ADDENDUM I
To Contract Documents for
EYECARE MEDICAL GROUP
53 SEWALL STREET
PORTLAND, ME 04102

E.M.G. - Phase 2 Addition & Renovation

EYECARE MEDICAL GROUP
PHASE 2 ADDITION AND RENOVATION
ADDENDUM NO. I
JUNE 26, 2013

A1	PLUMBING UNDER SLAB PIPING PLAN - PHASE 2	5	08-08-2013	ADDENDUM-5
1/8" = 1'-0"		No.	DATE	DESCRIPTION
		REVISION SCHEDULE

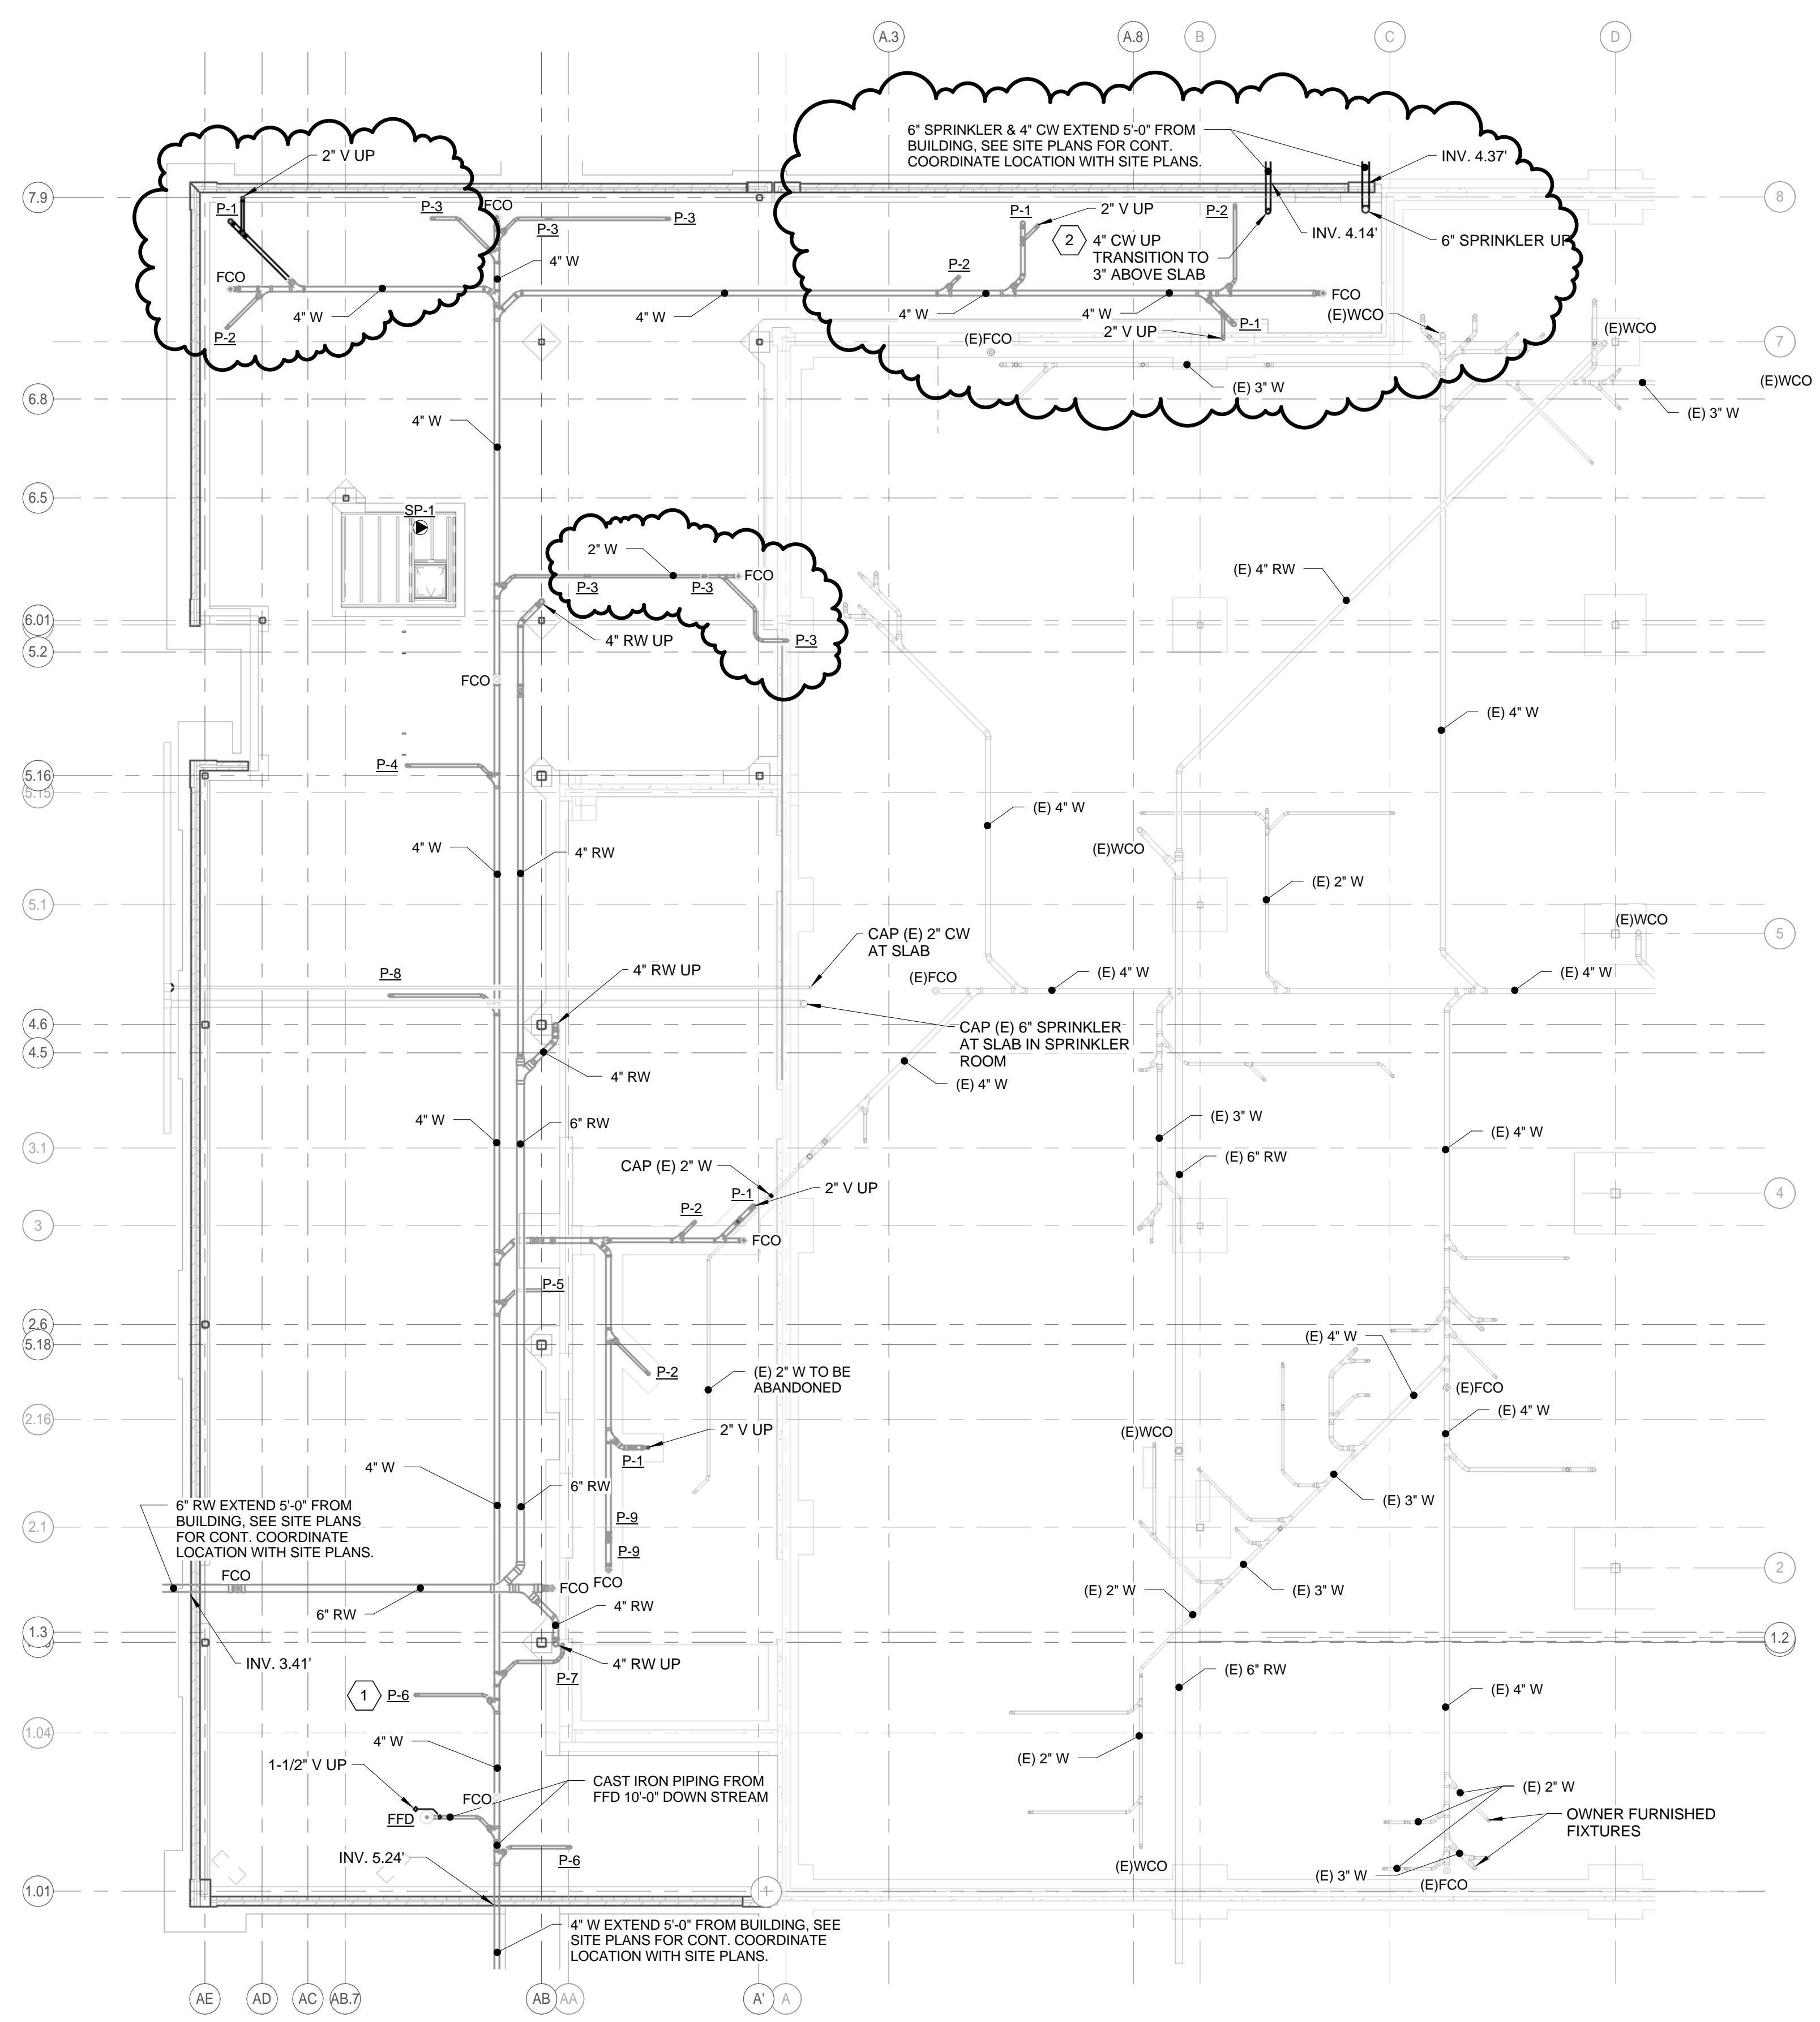
1. Sheet PL-100: CHANGE the size for the domestic water service, where located below grade and/or below slab, from 3" to 4".

2. Sheet PL-100: CHANGE Key Note N^o2 to read as follows:

“4” domestic water service shall transition to 3” above the floor slab. Rise into ceiling space, extend to existing sprinkler room, and connect, temporarily to the existing 2” service. The existing service will be upgraded as required under the Phase 2 interior fit-out package. All above floor domestic water piping shall be insulated as specified.”

Drawing file: 1. Original Plans / PL102 PLUMBING DOMESTIC PIPING PLAN.pdf

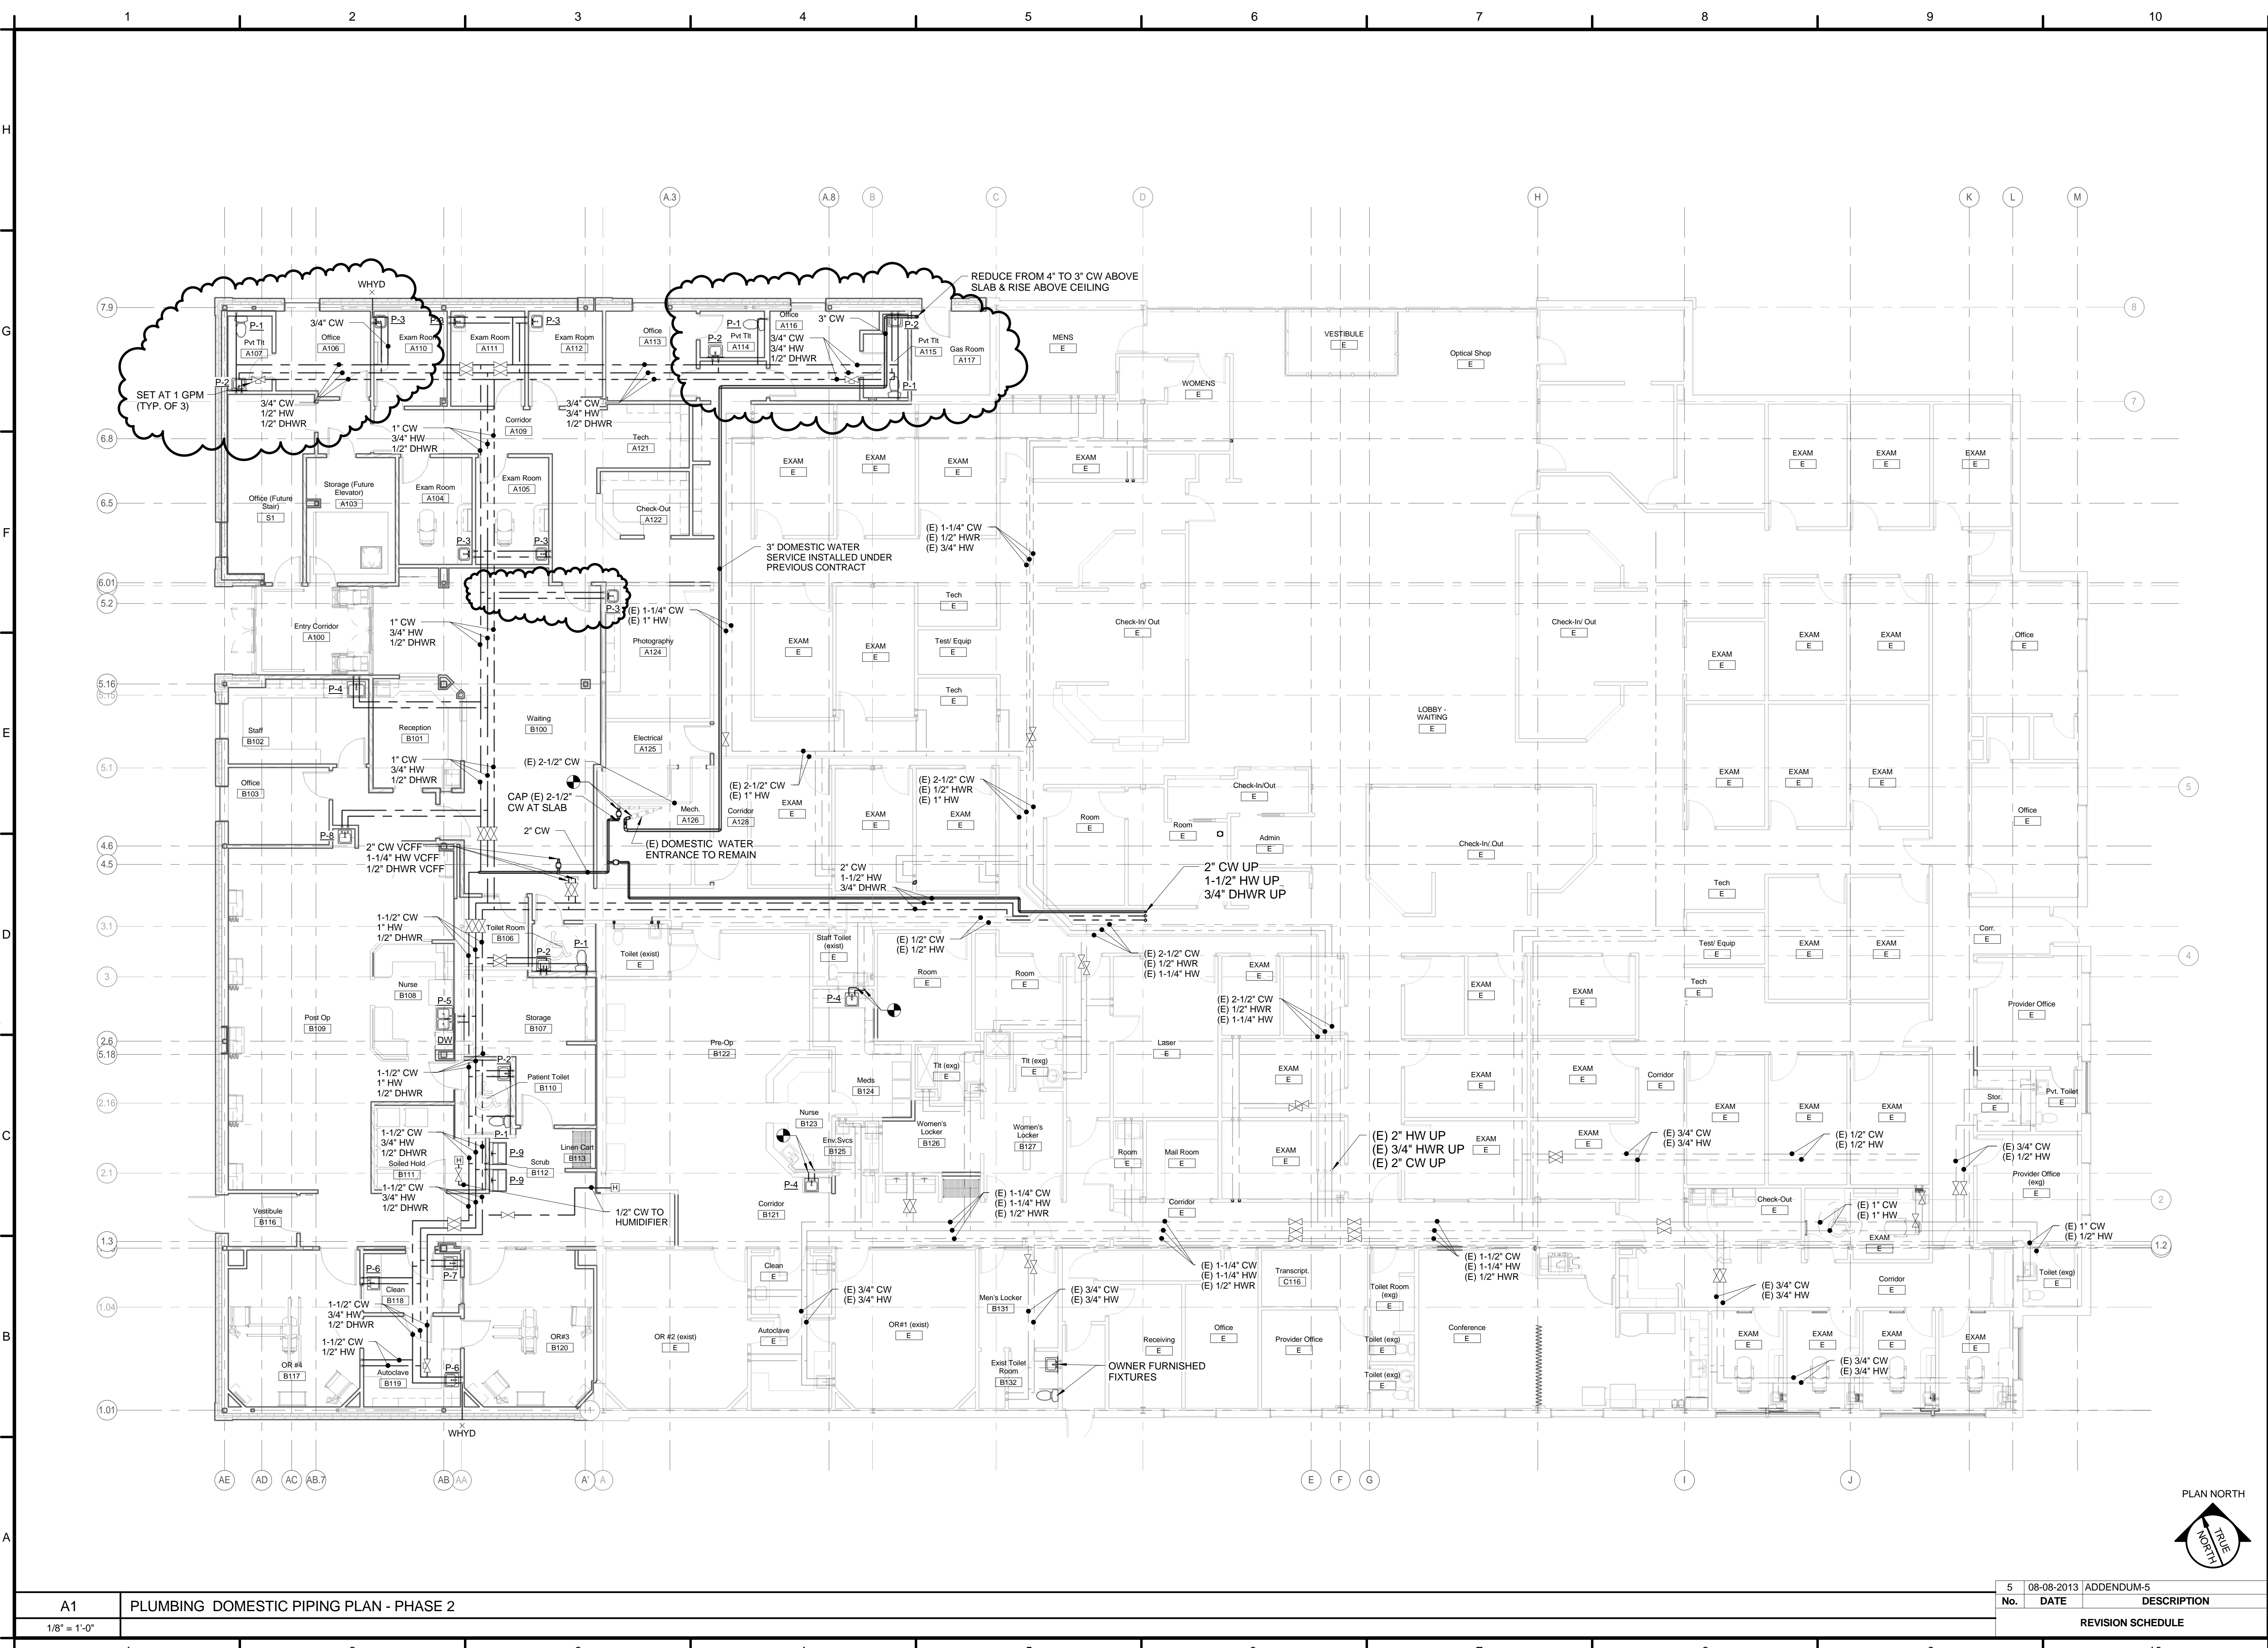
3. SHEET PL-102: ADD the following note to the sprinkler pipe as it enters the facility:

“All sprinkler service piping, where located above the future ORN^o3, ORN^o4, Autoclave BII9, and Clean BII8 spaces (scheduled for hard, non-accessible ceilings) shall be joint free or welded pipe to minimize the chance for leakage.”
